**Response to Agency Comments on Civil Drawings and Report – The Next Generation, Energy from Waste Plant, Eastern Creek**

We have reviewed all the Agency Responses to the Environmental impact Statement (EIS) for the proposed Energy from Waste Facility in Eastern Creek. Find below a summary of our responses to all the Agency comments for all civil and storm water related queries.

Below are AT&L's responses to Section 5, Engineering and Drainage Concerns, of BCC's SSD 6236 response.

Title
TYPICAL SECTIONS SHEET 1

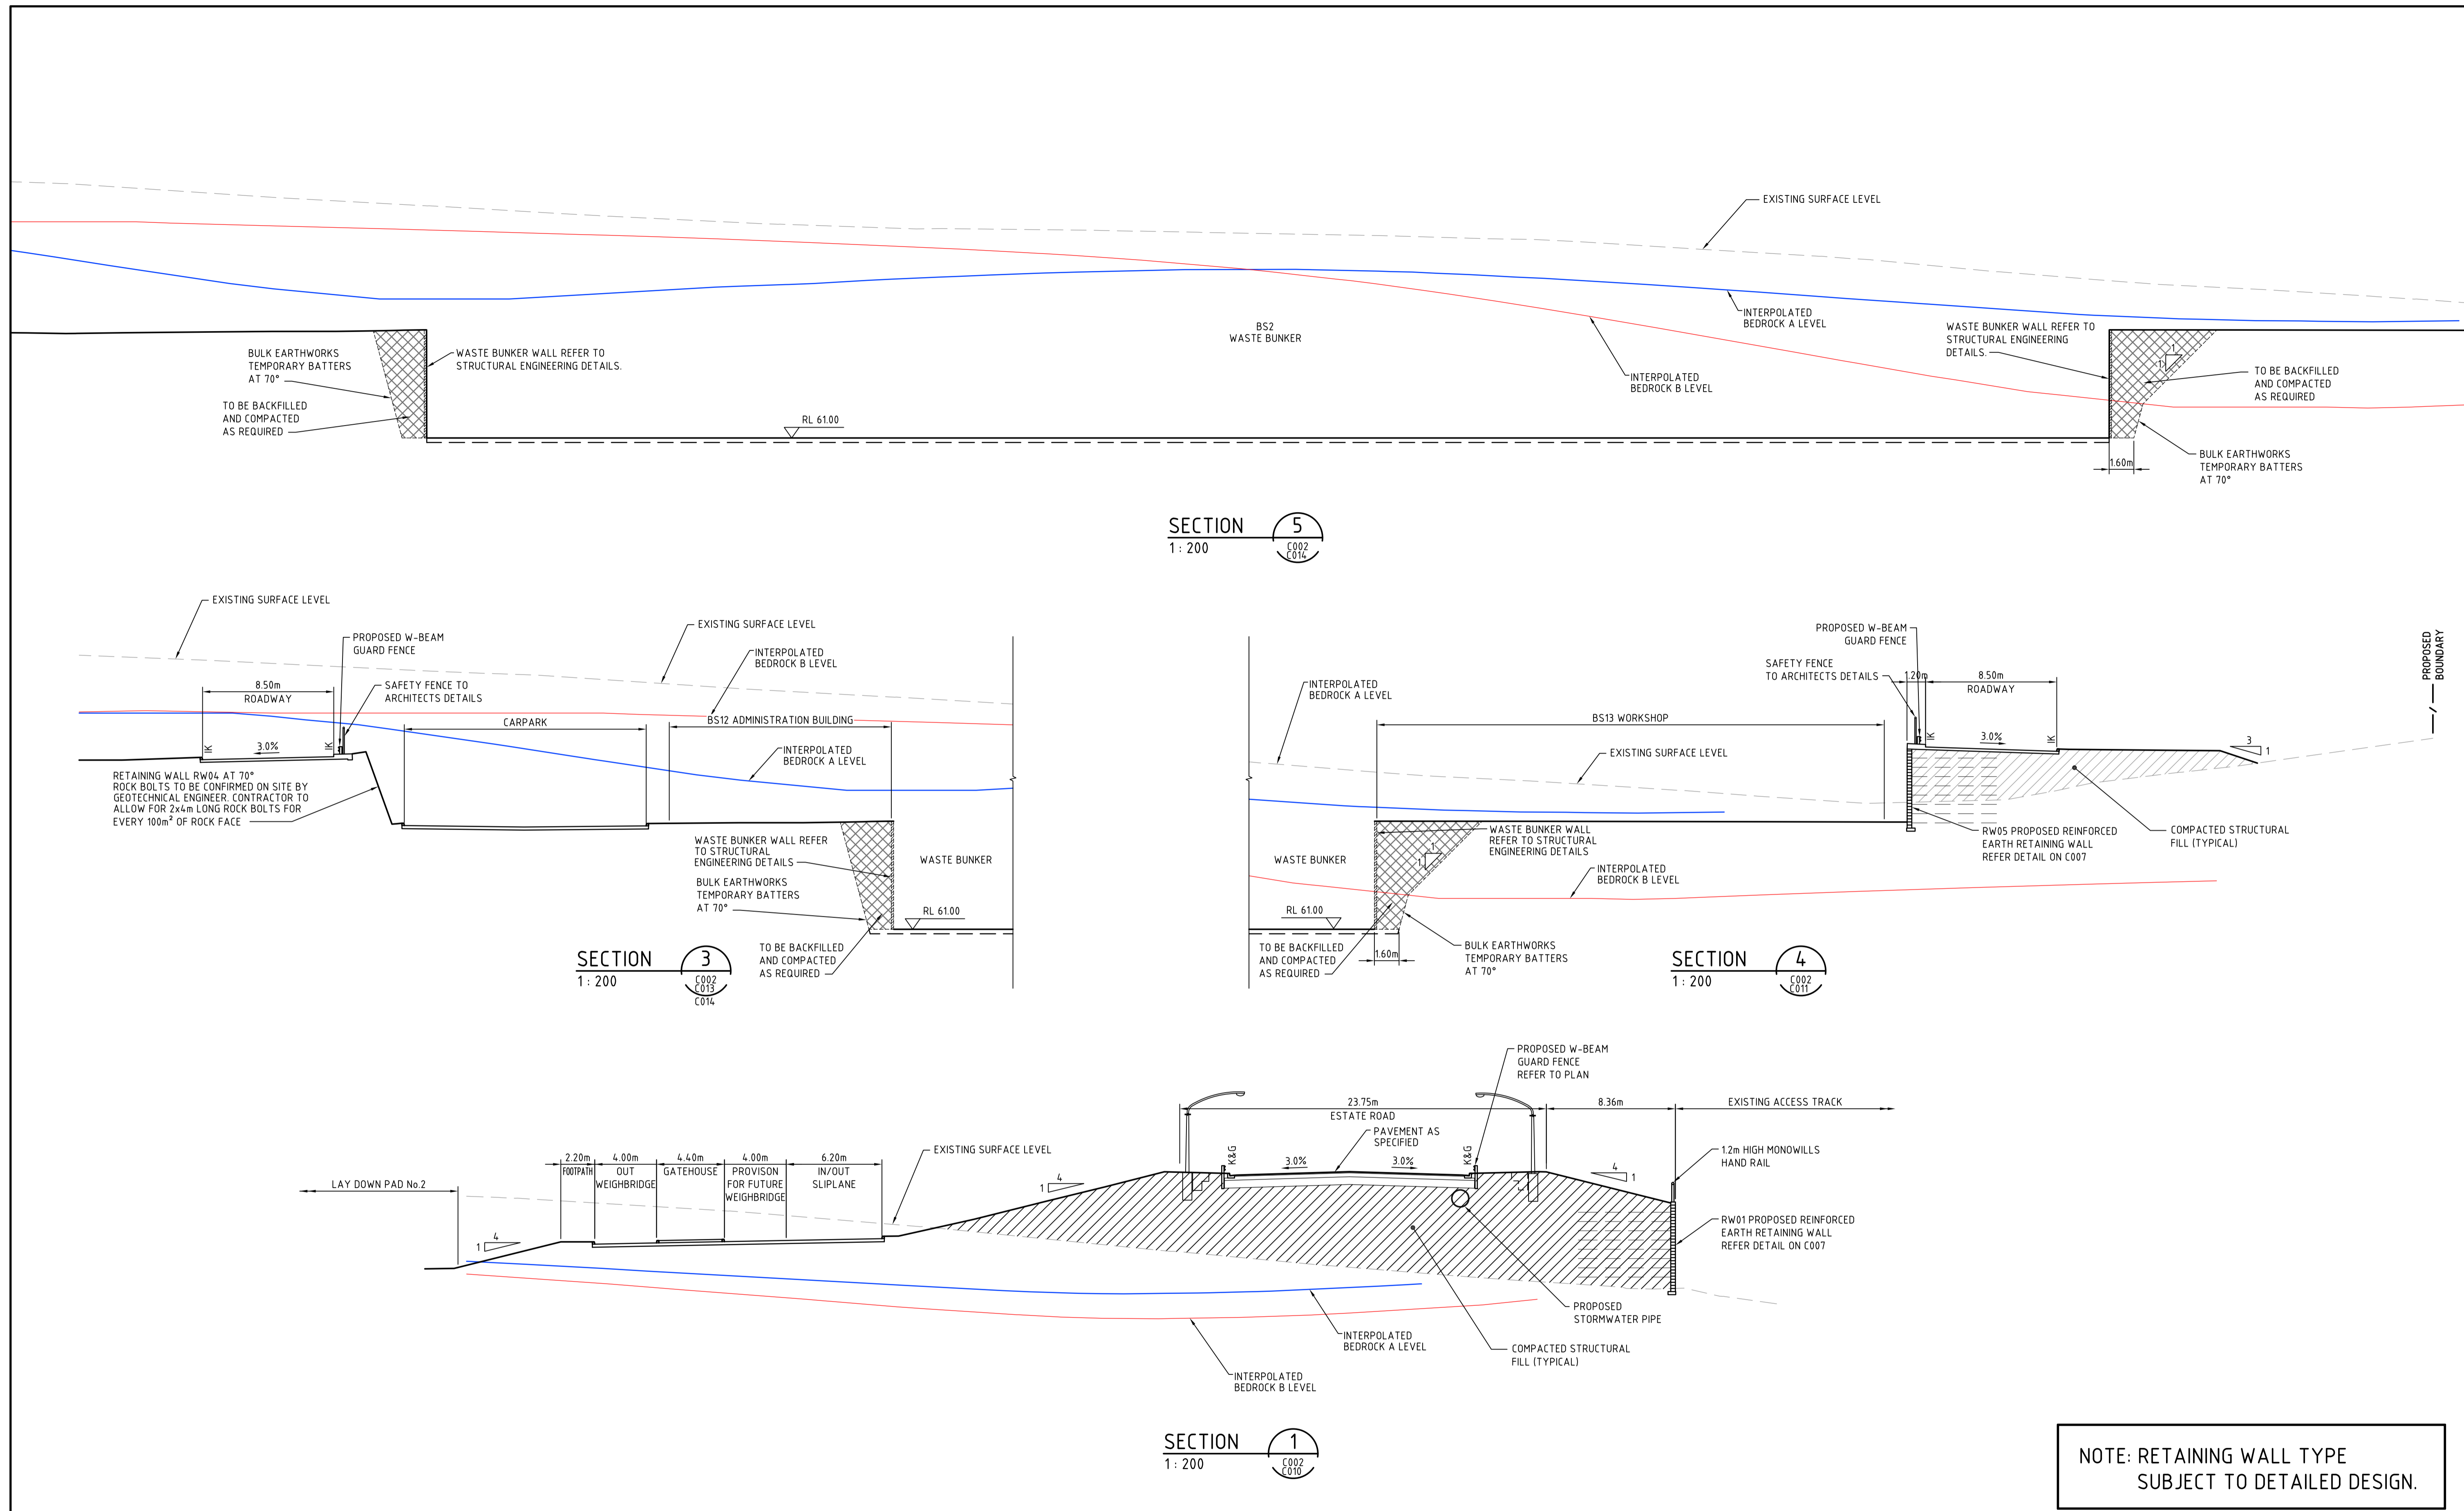
- a) *The applicant has advised that, as part of the EFW facility, no retaining work is required on the property boundaries. However, further cut and fill plans, together with all retaining wall details, should be obtained to confirm this is the case.*

**AT&L Response:** Civil Drawings issued to Blacktown City Council indicate there are no retaining walls required on the property boundaries. The bulk earthworks plan confirms this.
